**Application by Vattenfall Wind Power Limited for an Order Granting Development Consent for the Thanet Extension Offshore Wind Farm**

**Application by Vattenfall Wind Power Limited for the Thanet Extension Offshore  
Wind Farm Development Consent Order**

**WRITTEN SUMMARY OF ORAL REPRESENTATIONS**

**AT CAH2 ON 18.4.19**

Works Plan (Onshore) -  
Sheet 3 of 3

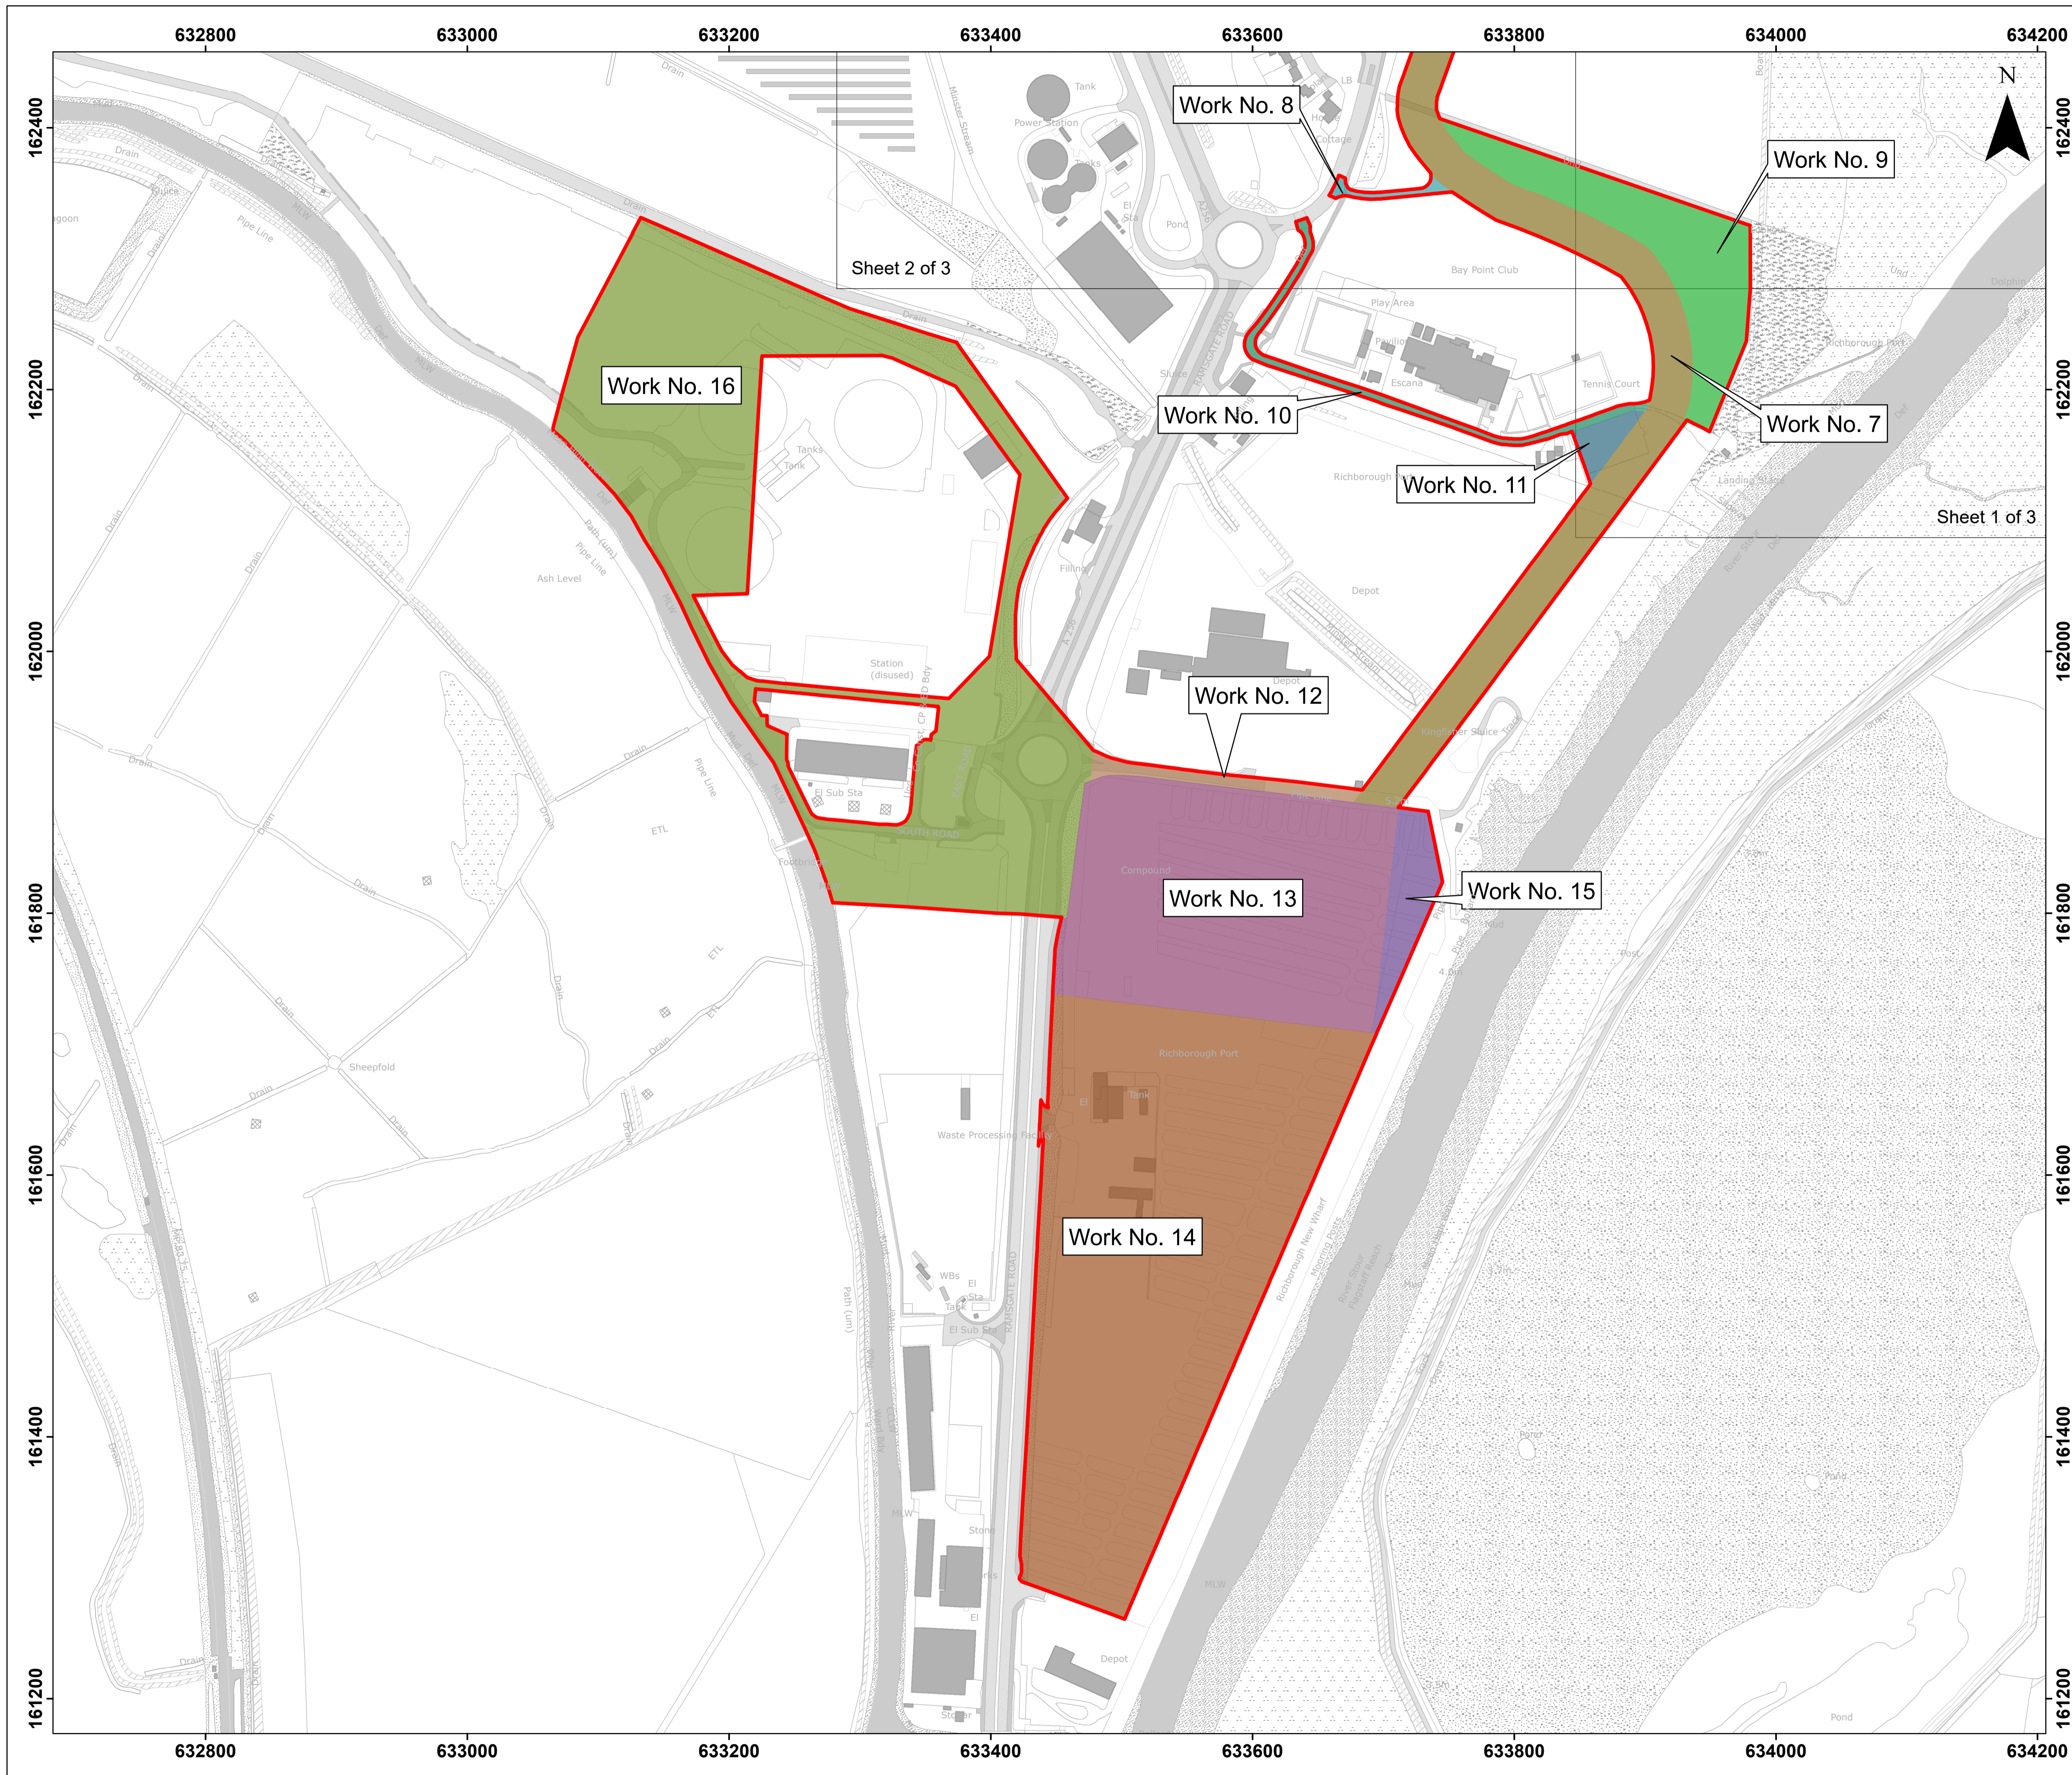
5. The Applicant's justification for the compulsory acquisition of Ramac's land – and principally that land comprised in Work No.13 (the onshore substation) is inadequate in the following respects:

- iii) If there is a valid reason for identifying Ramac's land as the most reasonable alternative, the Applicant has not explained or justified the selection of the particular parcel of land comprising Work No. 13. Ramac has made it clear to the Applicant since at least January 2018 (in its pre-application consultation response) that it would prefer the substation to be located further to the north of its landholding, at Baypoint Club or further to the south in the area identified for Work No.14. In its consolidated response to Ramac's consultation queries, the Applicant expressed the view that the siting of Work No.13 "minimises interference" with Ramac's operations. Ramac does not agree. It has consistently made it clear that it would prefer the substation to be

- iv) If the substation must be located on Work area 13, the Applicant has failed to justify the extent of the land-take proposed. In particular, it has failed to provide any technical analysis of the land requirements for a GIS substation as compared to an AIS substation. Ramac has consistently argued that a GIS system has the potential significantly to reduce the land-take. In its consolidated response to Ramac's queries as to why a AIS substation was proposed, the Applicant's response was that it wished to retain technical and commercial flexibility (see Applicant's response to query 8(3)). While the AIS requires approximately 8.5 acres, Ramac's technical expert, Robert Thorogood of Hurley Palmer Flatt, assesses that a GIS substation would require c.2.3 acres – a space saving of some 6.2 acres. It is to be noted that the NEMO link interconnector on the Richborough Energy Park uses a GIS substation and Mr Thorogood could not conceive of any technical reason preventing the use of GIS for this project. The Applicant has provided no technical analysis as to why that would not be possible here or any assessment of the comparative requirements of GIS or AIS. It is extremely disappointing that notwithstanding the fact that Ramac has questioned the use of AIS since January 2018, the Applicant was not able to provide a technical justification for its proposed use at the CAH1 in February 2019 and did not present any technical expert to justify its position at CAH2 in April 2019. Had Ramac known prior to CAH2
